INDEPENDENT REVIEW OF SAFETY RISKS

Narrabri Gas Project (SSD 14_6456)

For NSW Department of Planning, Industry and Environment

17 March 2020

Figure 6-21 Diagram of a typical three-well pad layout

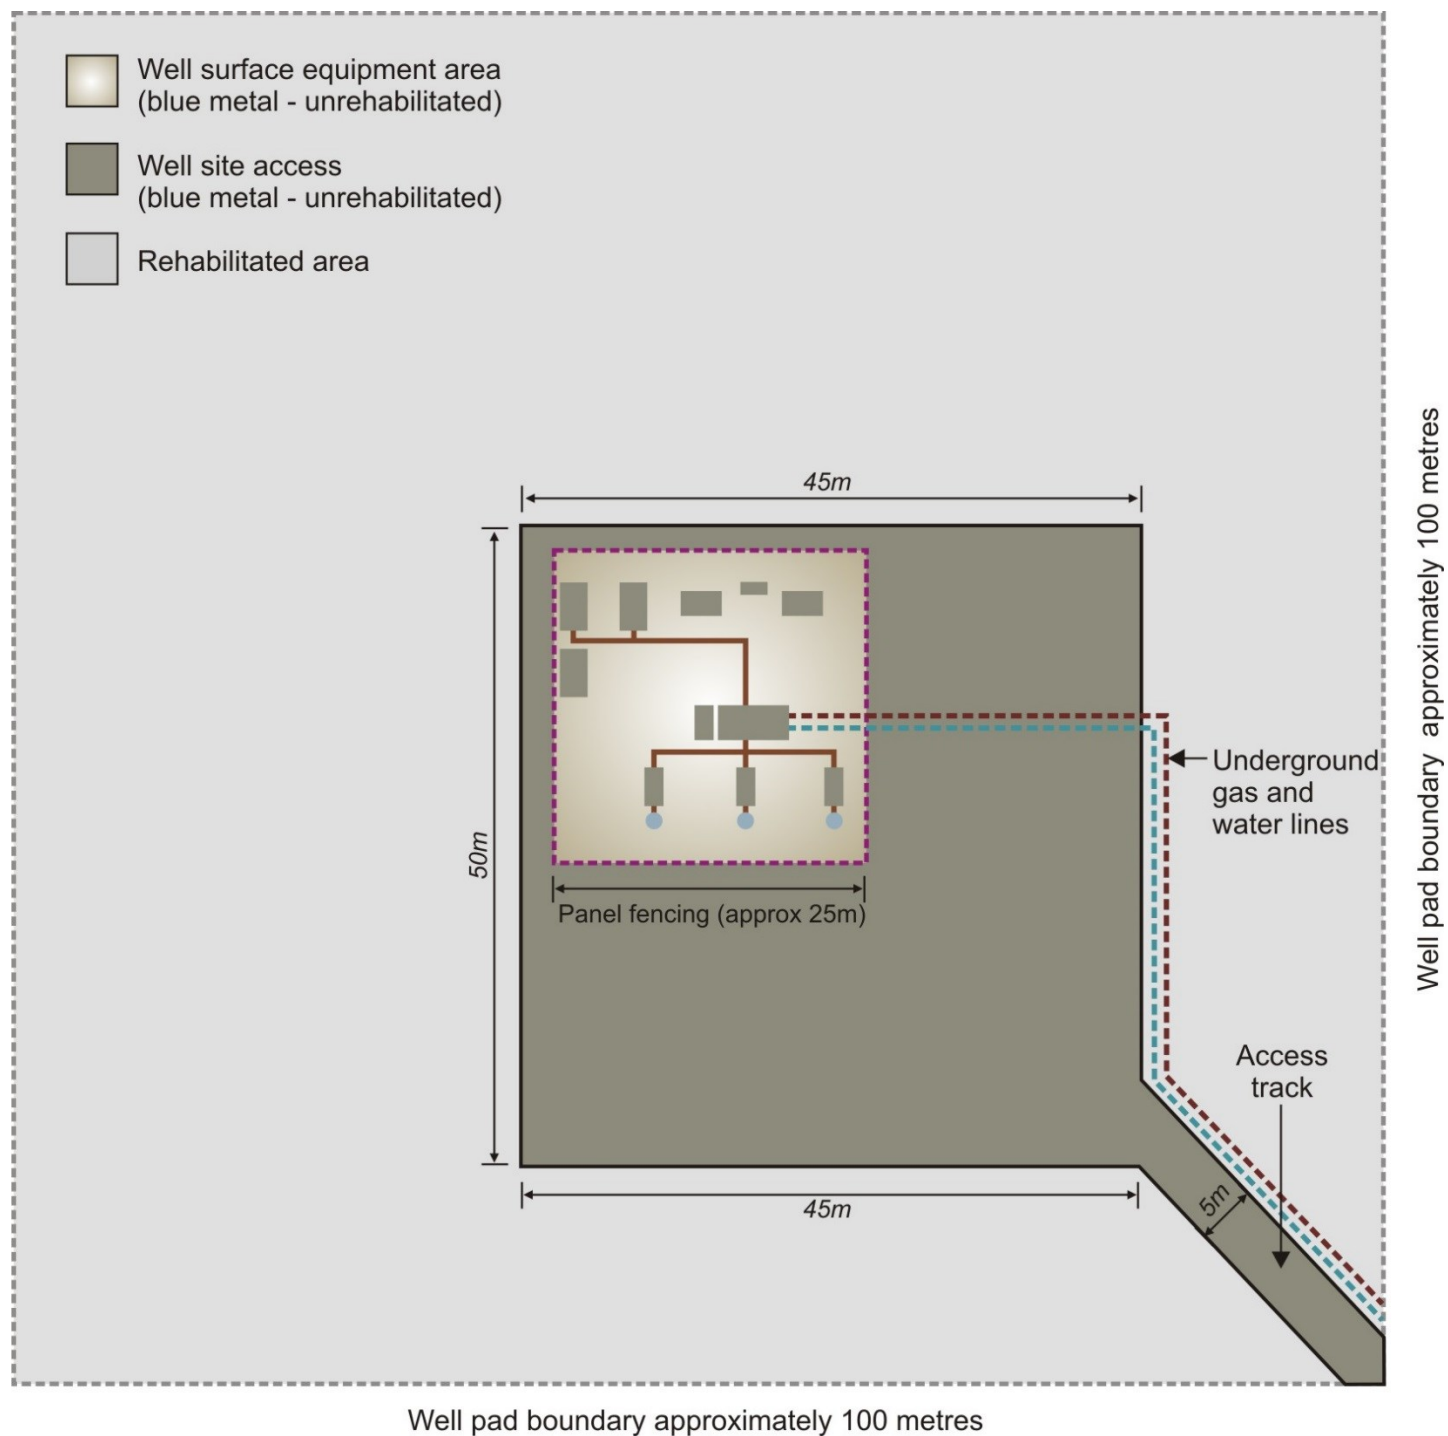
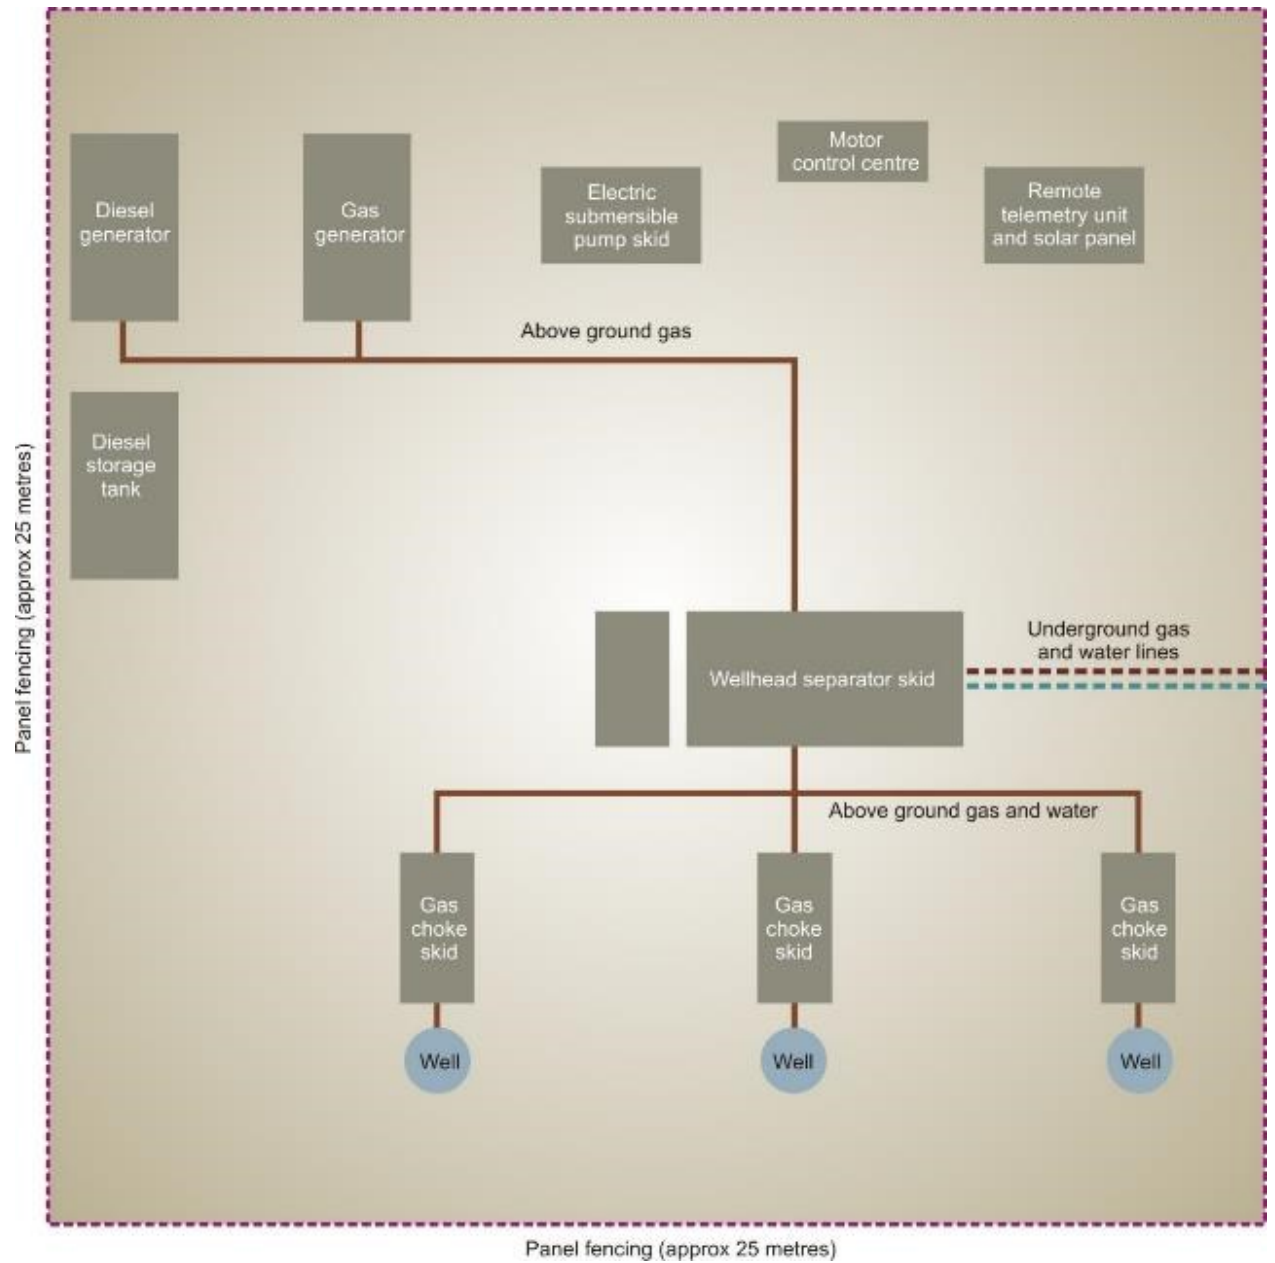
Clarifications were sought from Santos regarding the dimensions of the fenced off areas surrounding the CSG wellheads and gas infrastructure (Refer to CRS, ID # 8). The response from Santos included the following clarification:

Therefore, depending on the layout of the equipment within the operational well pad area, the separation distance from the wellhead and gas infrastructure to the boundary of the outer fenced 100×100 metre well pad area will range from 25 m to 50 m.

For an operating well that is not 'shut-in', the maximum extent of the 'off-site' impacts would appear to be c. 8 m to 25 m beyond the boundary of the outer fenced 100 x 100 metre well pad area (Based on the 'worst-case' consequence analysis results at a gas pressure of 620 kPag presented in Appendix S (Table 4-15) of the EIS for the NGP). However, the smaller, more likely, events may be fully contained within the outer fenced 100 x 100 metre well pad area (Based on the consequence analysis results presented in Appendix S (Appendix B) of the EIS for the NGP).

For a 'shut-in' well, the maximum extent of the 'off-site' impacts would appear to be c. 23 m to 46 m beyond the boundary of the outer fenced 100 x 100 metre well pad area (Based on the 'worst-case' consequence analysis results at a gas pressure of 1,400 kPag presented in *Response to Arriscar Pty Ltd's questions on the Narrabri Gas Project* (Attachment 1)).

"The project description in the EIS identifies that well pads will be approximately 100 x 100 metres in size (refer to Figure 6-21 in Chapter 6 of the EIS). This 100 x 100 metre well pad will be partially rehabilitated once production has commenced however will remain fenced throughout the operational life of the well. Wellhead and gas infrastructure will be located within a fenced 50 x 50 metre 'safety zone' within the operational well pad. Only water infrastructure, such as break tanks, and potentially temporary flares would be located on the operational well pad, outside of the safety zone. The potential for offsite impacts will be taken into account in layout optimisation during the design phase."

Whilst some 'off-site' impact may be credible for a 'worst-case' event, it would appear that the outer fenced 100 x 100 metre well pad area may provide an adequate set-back on a safety risk basis (Noting that the individual and societal risk criteria in HIPAP No. 4 would apply for the land uses at the proposed CSG well locations) and it is reasonable to optimise the layout of equipment during the design phase. It is recommended that this be demonstrated in the Final Hazard Analysis.
